Planning Officer: Andrew Wood

Planning Application Ref: M/155/18/PL

Location: 5 Central Drive, Middleton-On-Sea, PO22 7TT

Description of works: Replacement dwelling (resubmission following M/114/18/PL).

PROJECT TITLE Proposed development at 5 Central Drive	DRAWING TITLE Proposed Site & Location plan		No	REVISION	DATE
	STATUS Planning Application				
	SCALE As noted	DATE 14.12.2018			
	DRAWN BY AP	DRAWING No PA-270-10

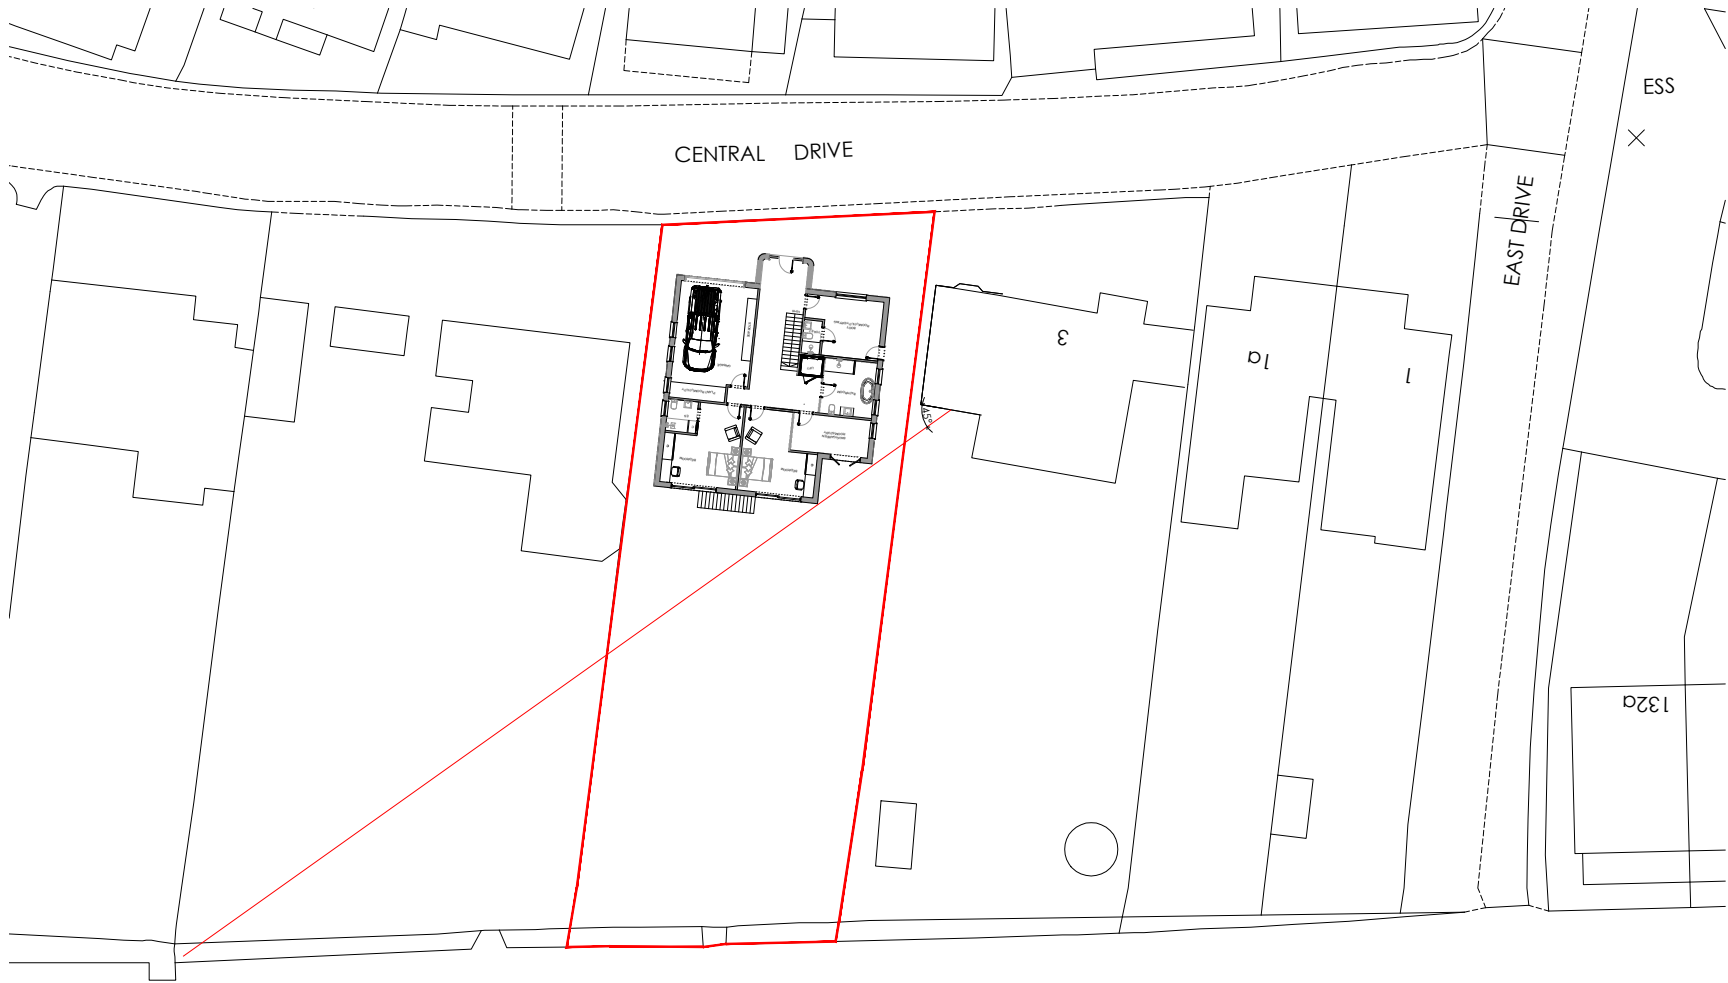
- The proposal will involve the demolition of the existing dwelling, extraction of existing hard surface materials and construction of new building footprint within a large percentage of tree root protection area (RPA). The dominant tree is a large, over-mature off-site Monterey cypress, growing at the front of number 7 Central Drive and immediately adjacent the party boundary. In addition to the root spread (nominally 11m radius) the crown extends far over the existing dwelling. All this considered and despite it having an established relationship with the existing property; the tree represents a significant and challenging constraint to the development now proposed.

- The proposed drainage layout represents a further incursion at depth into tree RPA's, with potential for significant harm to the aforementioned neighbouring tree.

- The applicants will need to employ the services of an Arboricultural Consultant to carry out a tree survey exercise and then prepare a brief report which must be inclusive of; 'Tree Survey' and 'Root Protection Area' Schedules.
- As the RPA of trees proposed for retention overlap the development, BS5837:2012 requires that this application must also be accompanied by an Arboricultural Method Statement (AMS) and a Tree Protection Plan – to both describe and illustrate the mitigation measures which are to be employed to ensure that the trees survive without detriment to their vigour and vitality and are given adequate protection both above and below ground.

PROJECT TITLE Proposed development at 5 Central Drive	DRAWING TITLE Proposed Elevations		No	REVISION	DATE
	STATUS Planning Application				
	SCALE 1:100 @ A3	DATE 14.12.2018			
	DRAWN BY AP	DRAWING No PA-270-07

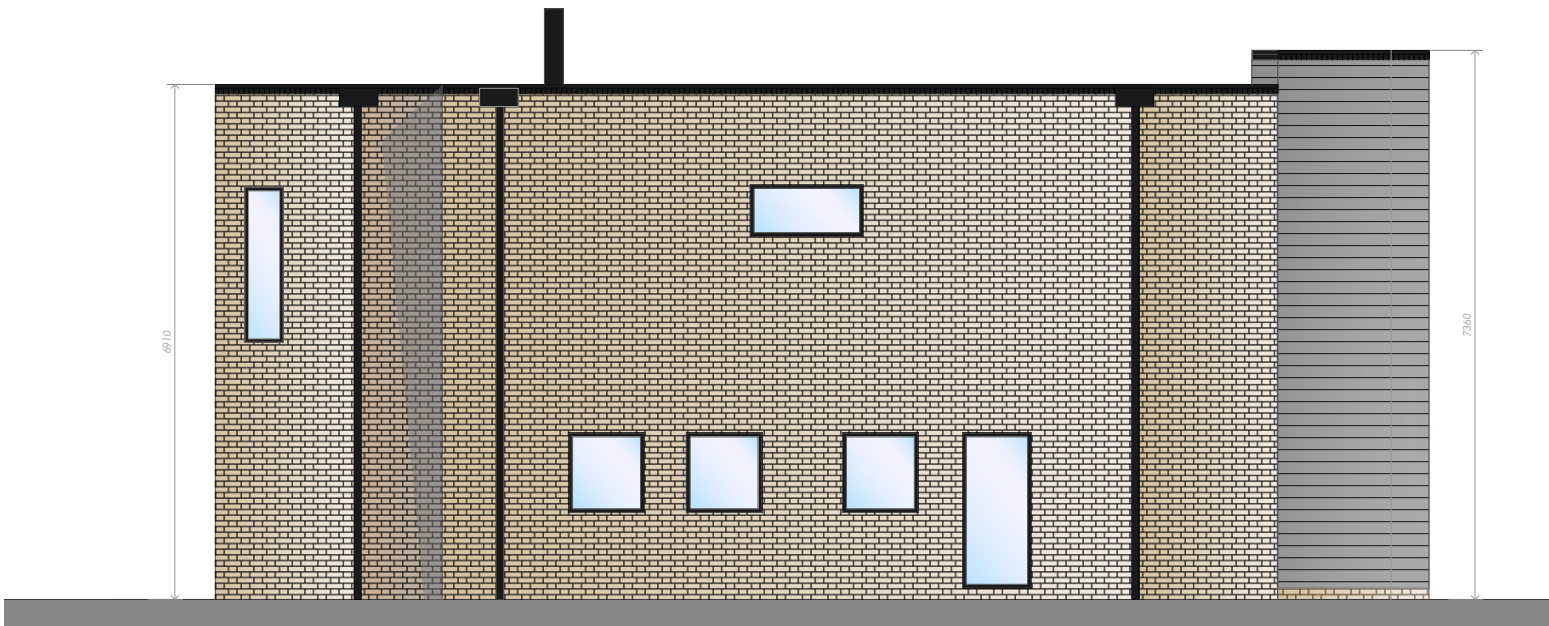
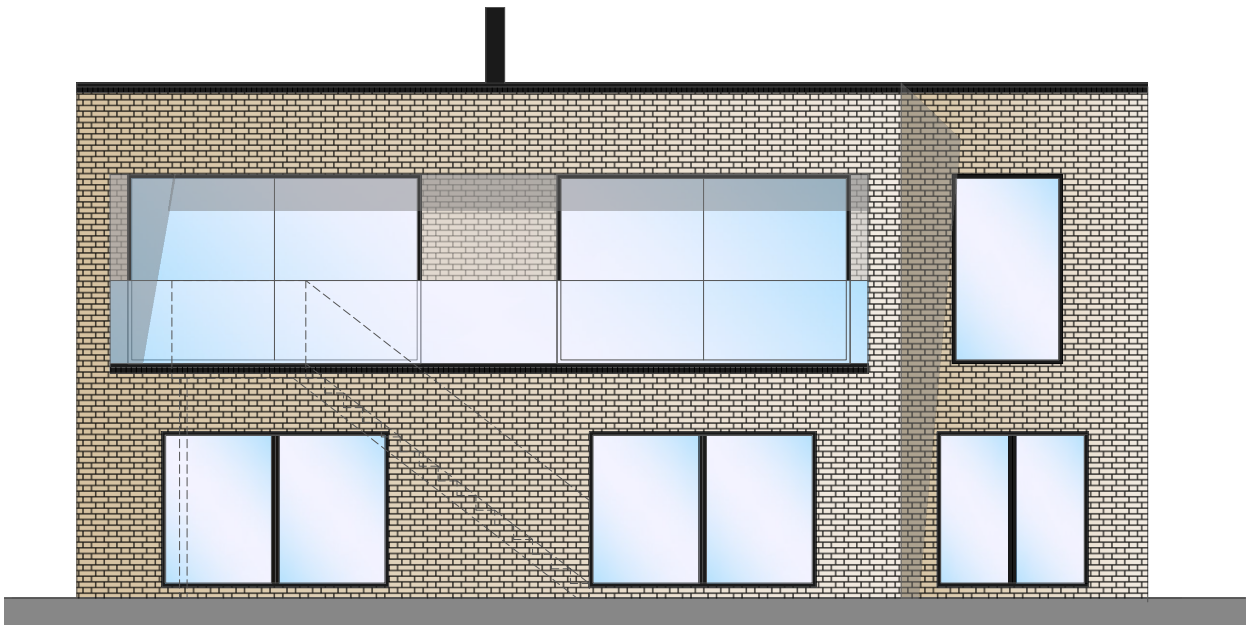
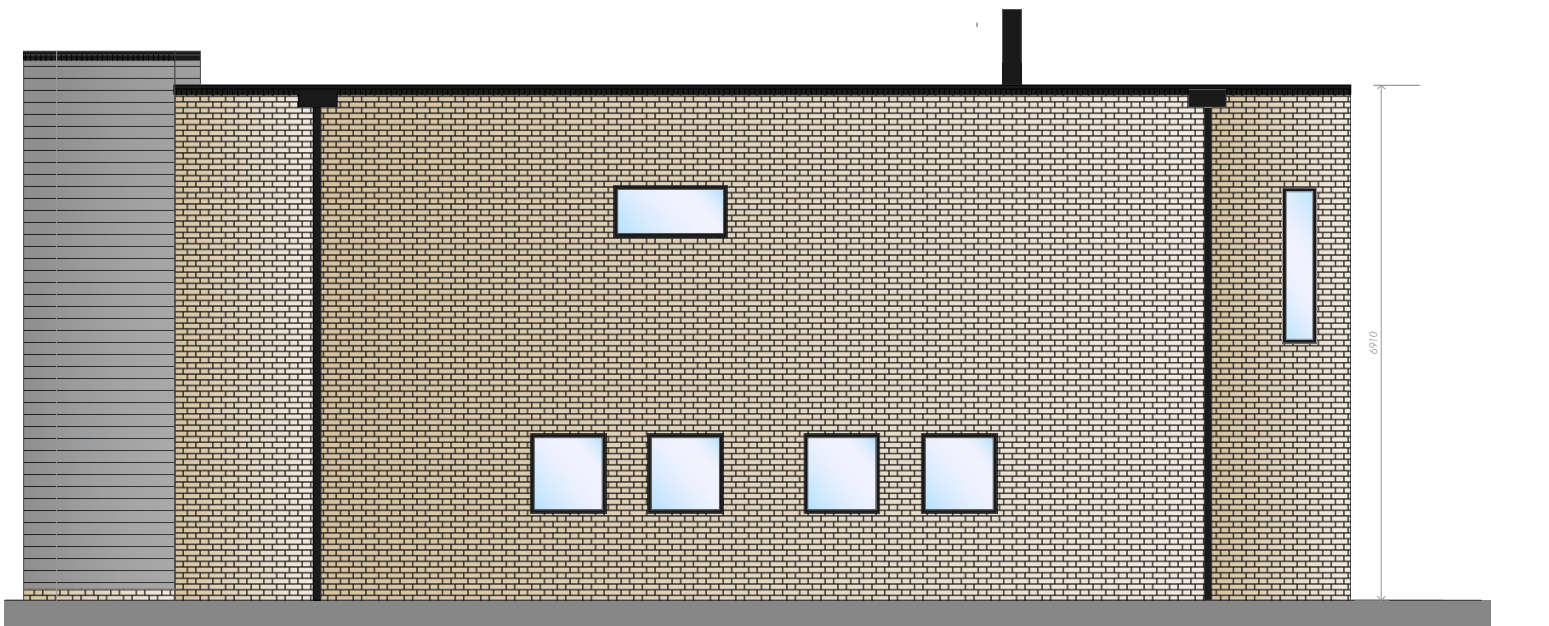
- Facilitation pruning will be necessary to accommodate the latest building design, which has a higher west facing elevation – further impacting on the ongoing health and vitality of this impressive tree. It is perhaps not worthy of a Tree Preservation Order, although this is primarily due to its having outgrown its context rather than any other condition or visual related property.

Tree Retention and Protection Plan

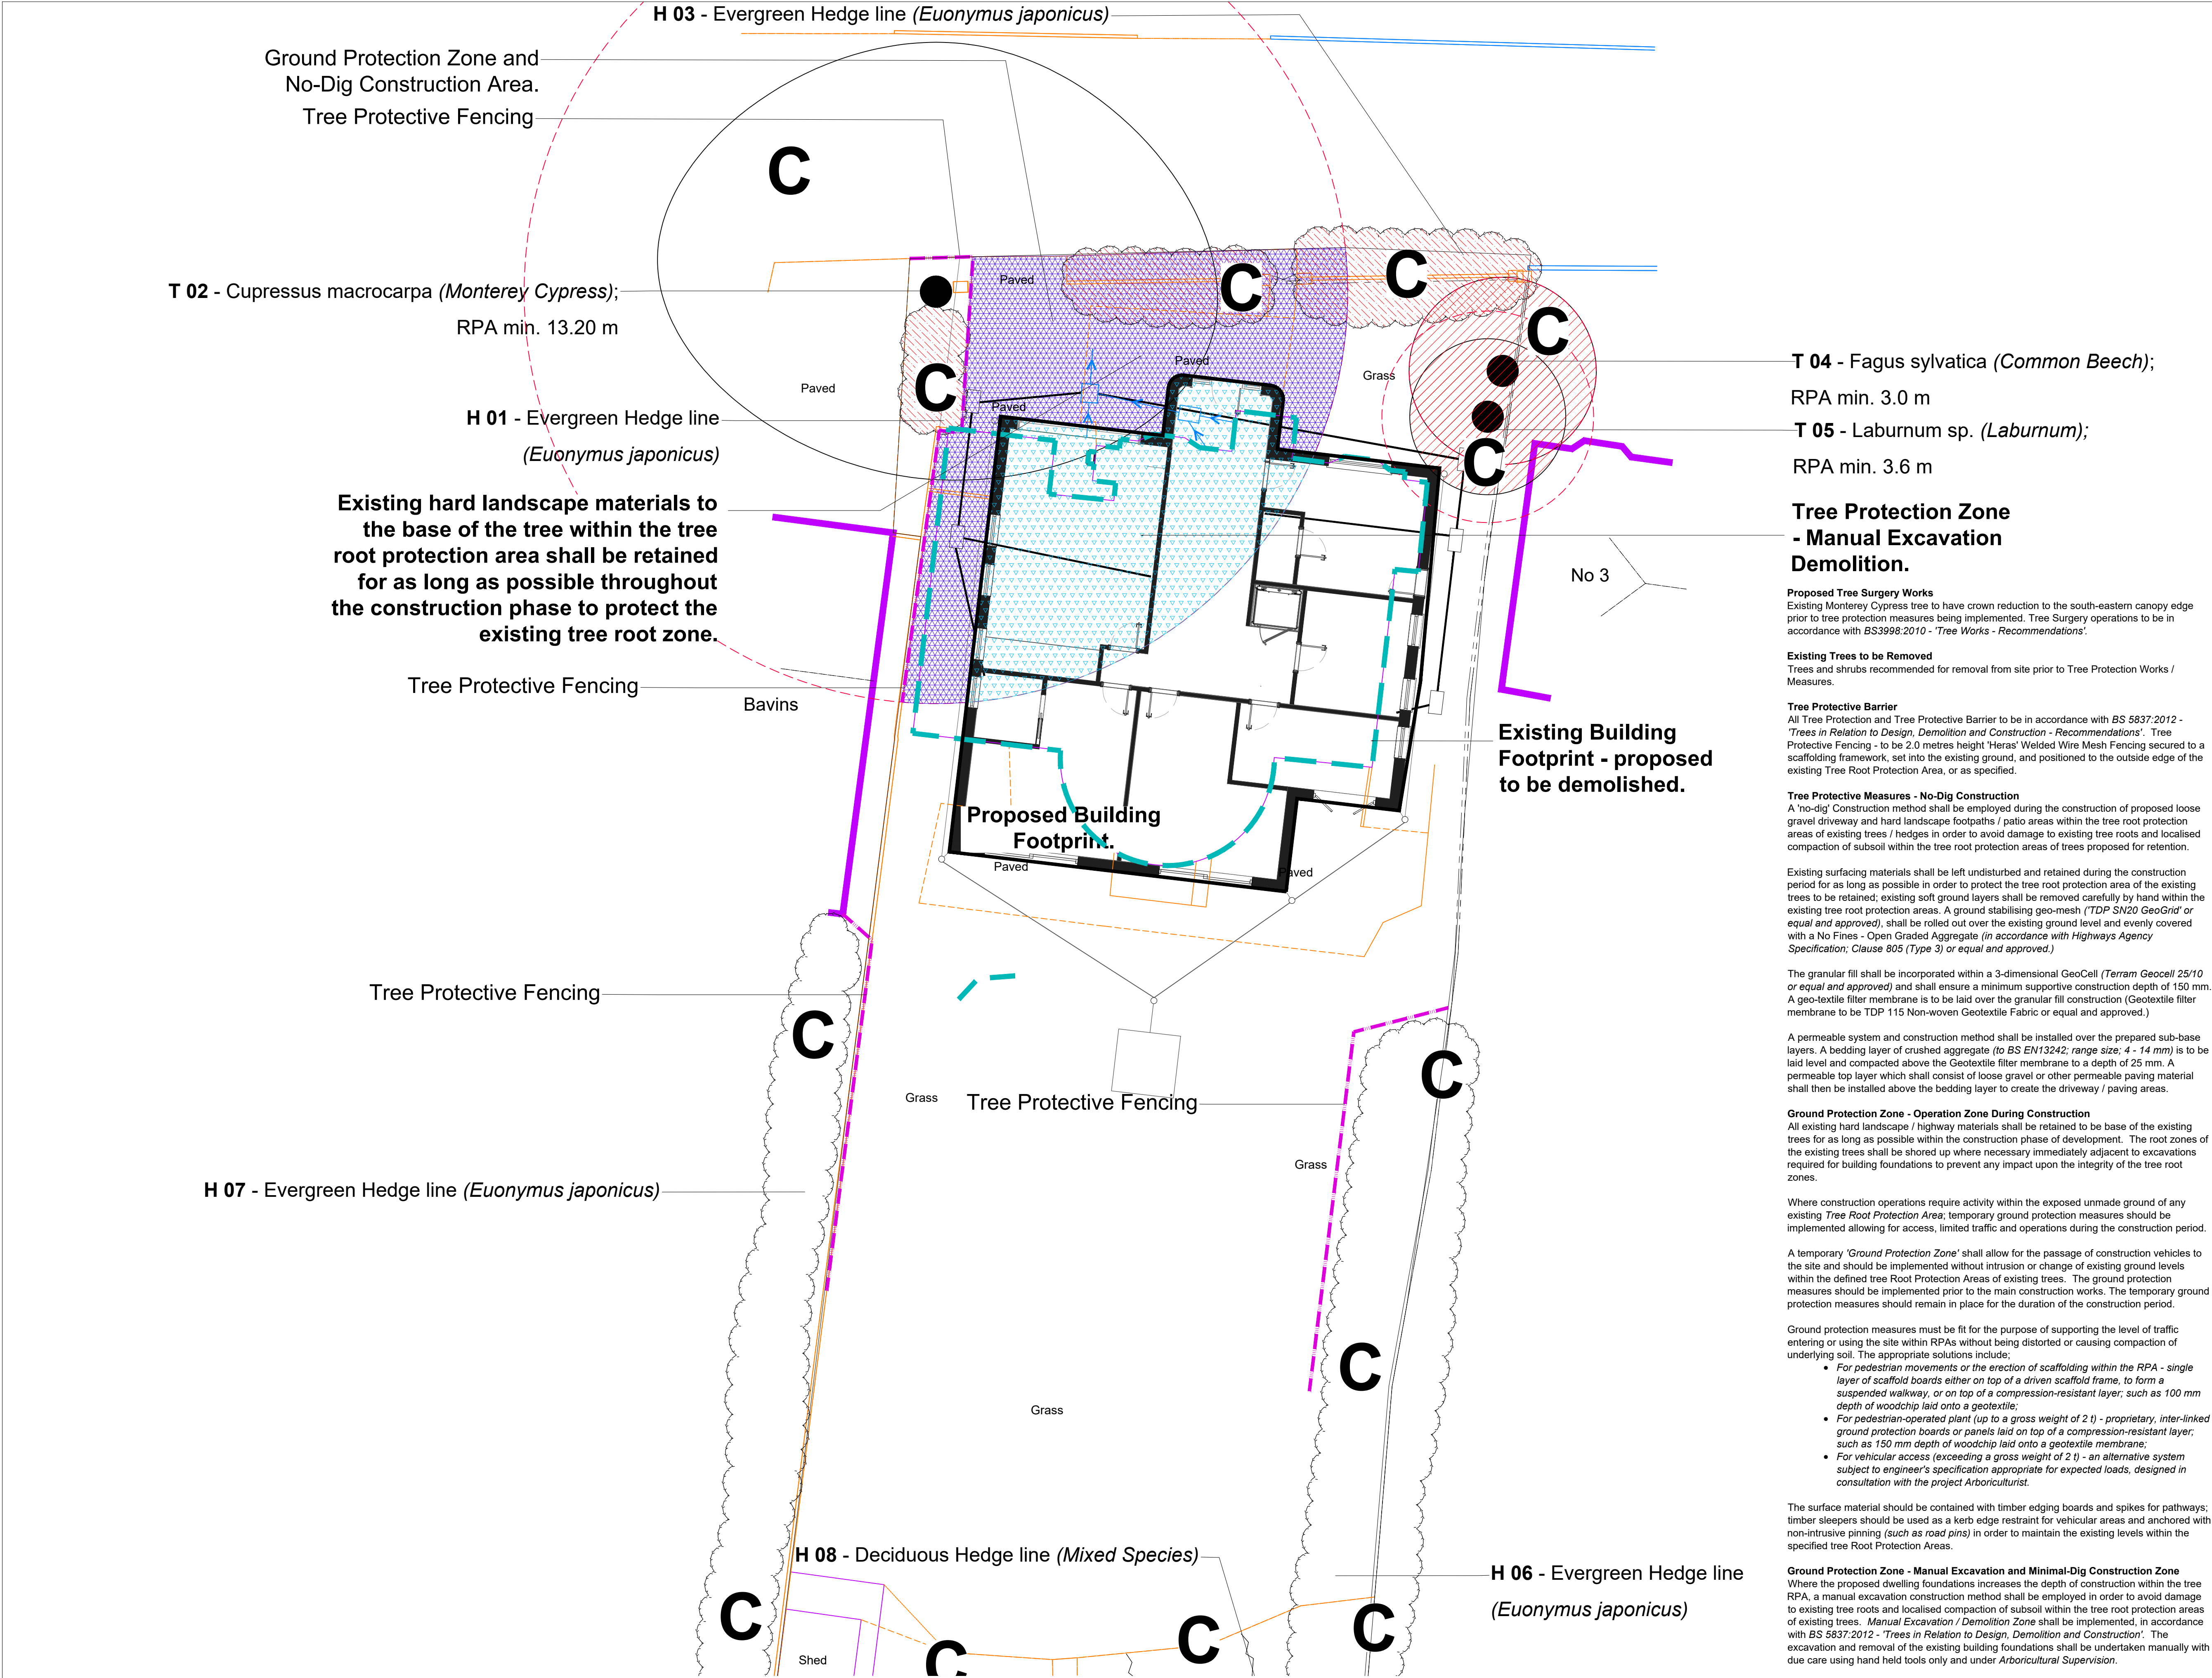
- There are significant trees on/off this site which might be adversely affected by the proposals. No arboricultural information has been submitted with the application - a requirement of BS5837:2012. As such, were this application to now proceed, we will not have sufficient information to guarantee such trees would be adequately respected and protected.
- As it stands, in the absence of any detailed arboricultural information to support the application I must register an OBJECTION.
